**Consultation Response from Mike Hibbert,  
 KC Waste Strategy( Refuse & Recycling)**

**2023/90024 George Hotel, St George's Square, Huddersfield, HD1 1JA**

**Partial demolition of a Listed Building to facilitate refurbishment and extension of the George Hotel to form a 90+ room C1 hotel with associated ancillary uses (including bar, restaurant, gym, conference room) (within a Conservation Area)**

Car Park 1
Existing Total: 41 no.
Proposed Total 36 no.

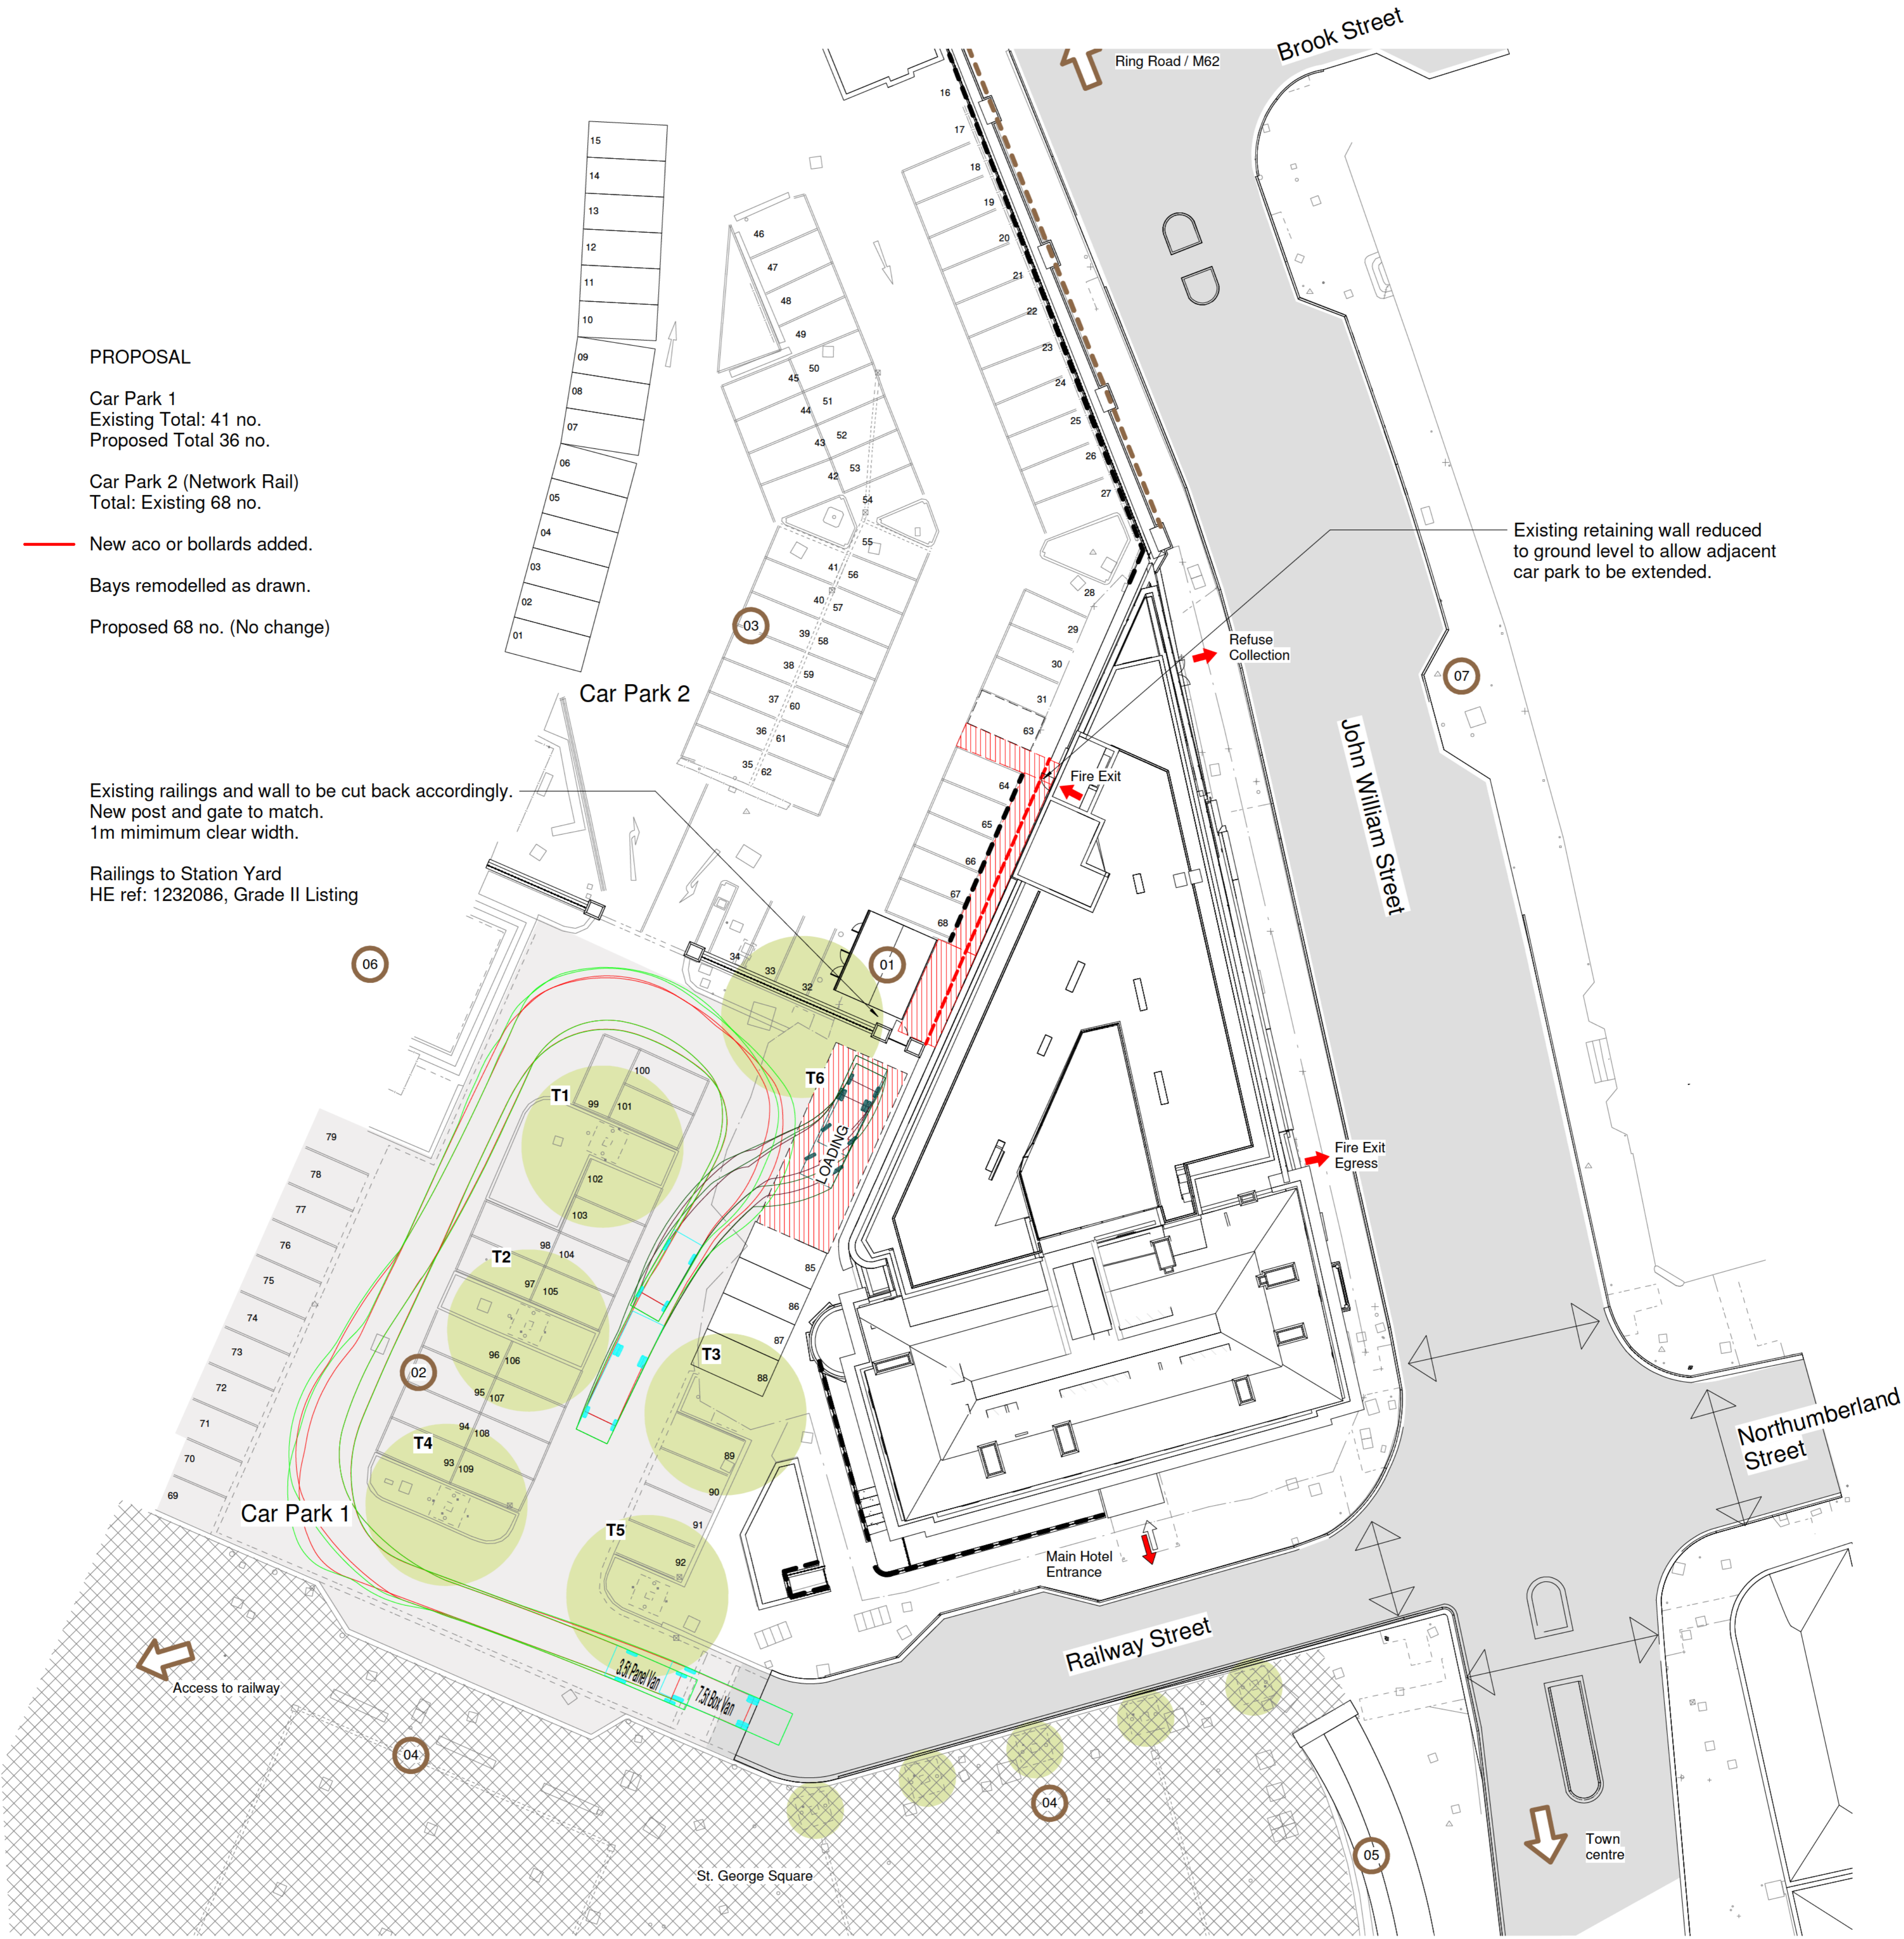
The Transport Statement December 2022 includes a plan showing the location for refuse collection.

- Storage of waste containers on the pavement or highway adjacent on John William Street is unacceptable.

- Suitable site access and manoeuvrability space for a Refuse Collection Vehicle is vital. This obligation will exist in perpetuity on any development and as such will be a critical consideration in the layout of the site.
- John William Street is a busy traffic route and therefore additional details are required about the access to the waste store or Bin Collection Point and how this will be serviced via an RCV, FEL or skip wagon. Unless active measures are taken parked vehicles may prevent collection or cause collection vehicles to block the carriageway. Any proposals should consider the potential impact on pedestrians and motorists when waste collection is occurring at the site.
